KIRKLEES METROPOLITAN COUNCIL INVESTMENT & REGENERATION SERVICE

DELEGATED DECISION TO DETERMINE PLANNING APPLICATION FOR ADVERTISEMENT CONSENT

Reference No:	2022/64/91742/E
Site Address:	11-13, Branch Road, Batley, WF17 5RY
Description:	Advertisement consent for erection of illuminated sign (within a Conservation Area)
Recommending Officer:	Nina Sayers

DECISION – GRANT ADVERTISEMENT CONSENT

EAST ELEVATION
SCALE 1:100
PROPOSED - P003

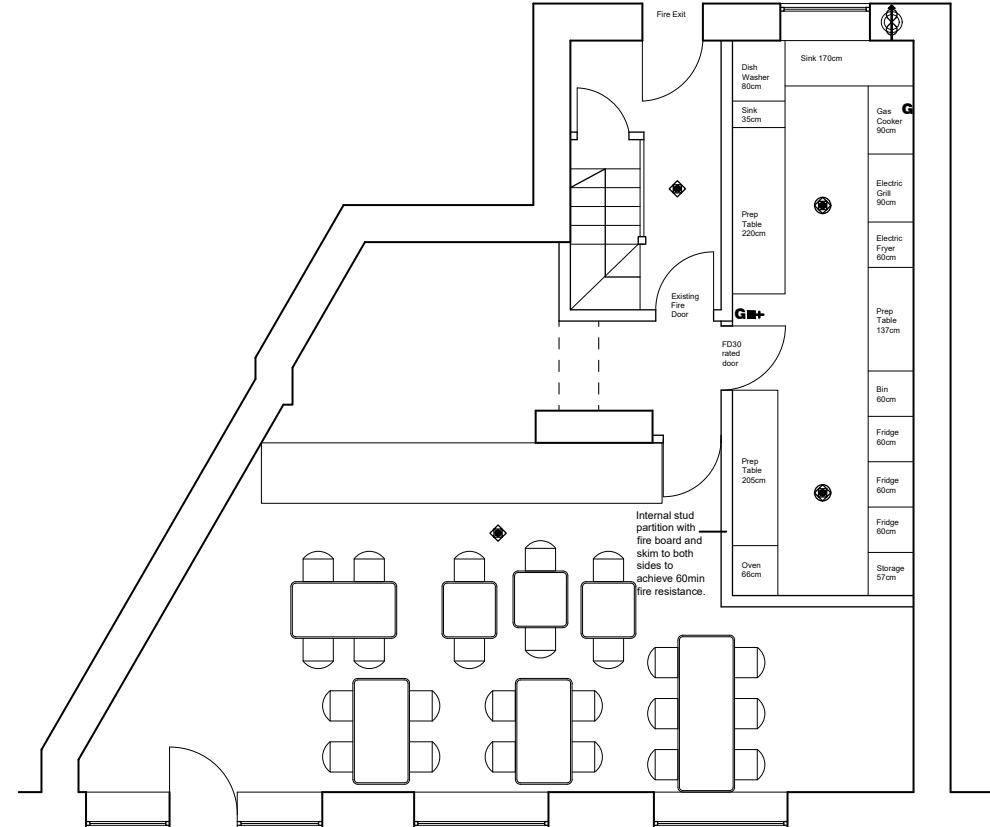
Officers had concerns regarding internal illumination and the impact on the historic character of the conservation area. Amended plans were sought and received which showed external lighting.

KC Conservation and Design officers were consulted regarding this application site being located within Batley Marketplace Conservation Area. They requested the internal illumination was amended to external lighting in the interest of visual amenity and preserving historic character. Following amended plans, they have no objections.
